13 July 2020

TfNSW Reference: SYD19/01554/02
Council Reference: SSD 10404

**RESPONSE TO SUBMISSIONS - HORSLEY DRIVE BUSINESS PARK STAGE2 BUILDING1
CNR COWPASTURE ROAD AND TRIVET STREET, WHETHERILL PARK**

**1 OVERALL SITE PLAN**  
 A150 Scale: 1:1000

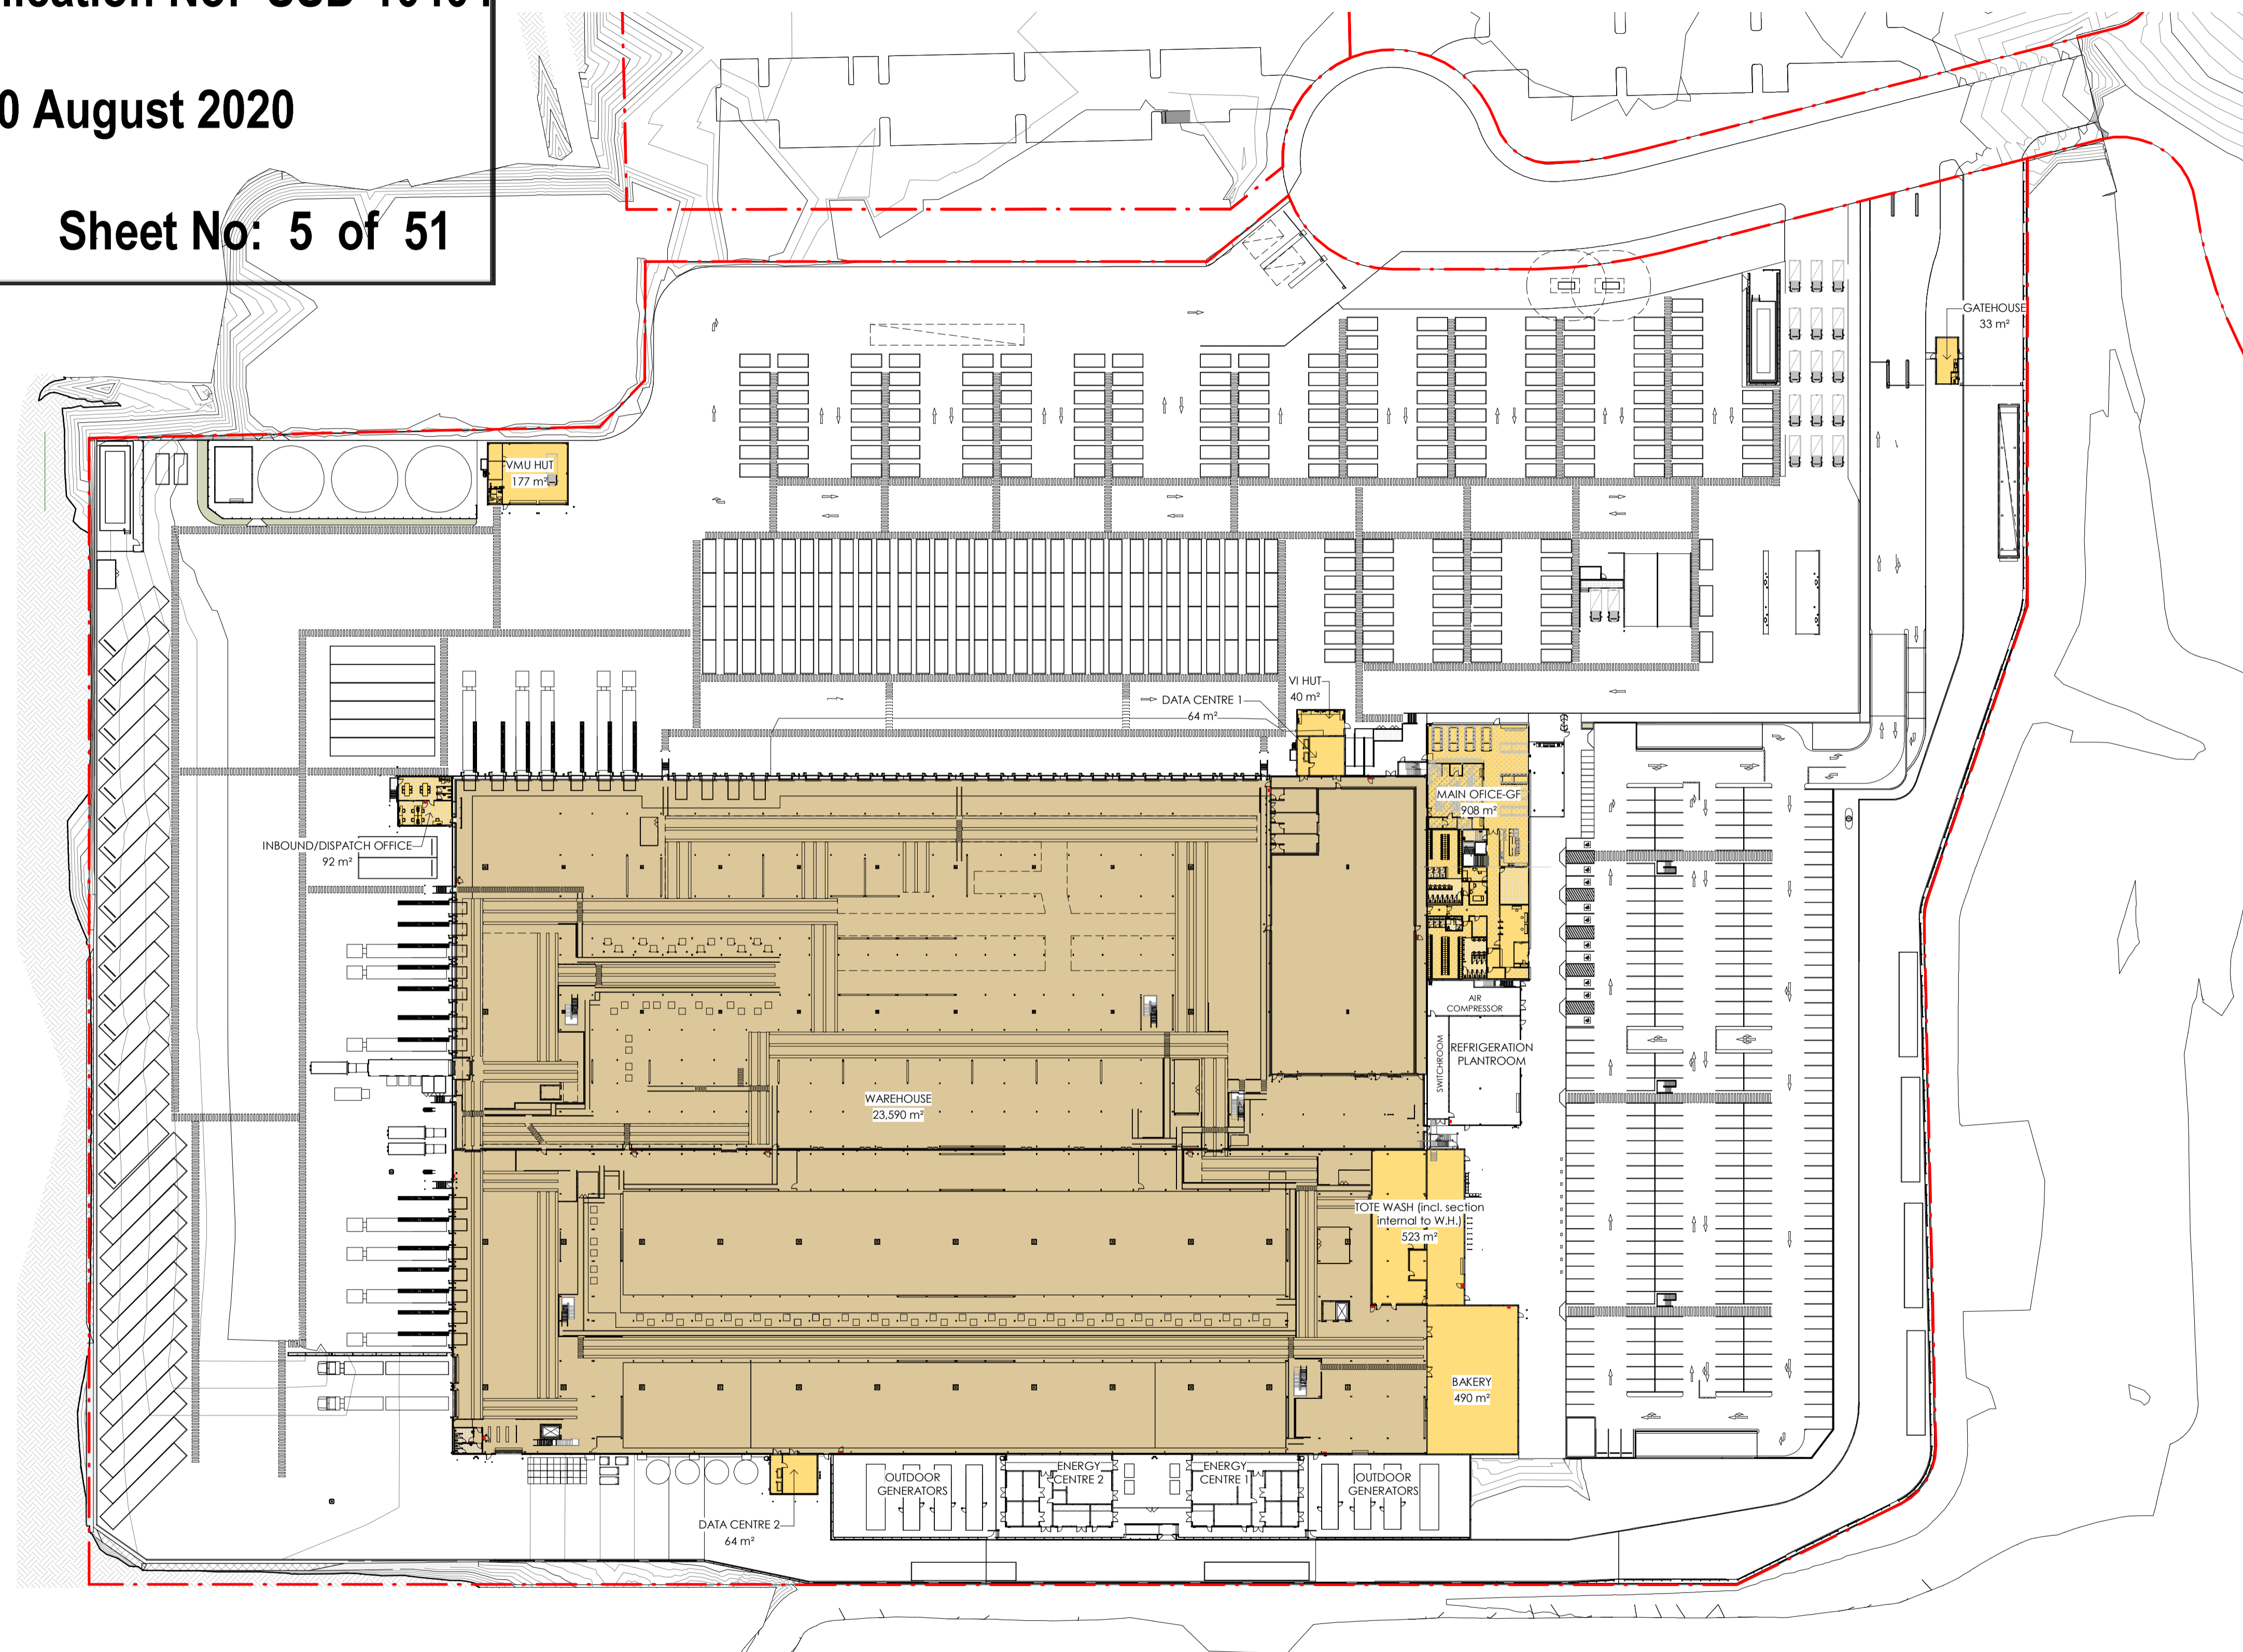
- It is noted that the applicant is proposing to change the alignment along Cowpasture Road, close section of Cowpasture Road and create a Cul-de-sac. Justification for these changes on Cowpasture Road at the access to the site and how this will improve safety or accessibility along this section of Cowpasture Road need to be provided to Council.
- The closure of the section of Cowpasture road and the realignment of Cowpasture Road would require a Traffic Management Plan to be provided to Transport for NSW by Council for review. A public consultation will also be required. The applicant is to liaise with Council to prepare the required Traffic Management Plan.
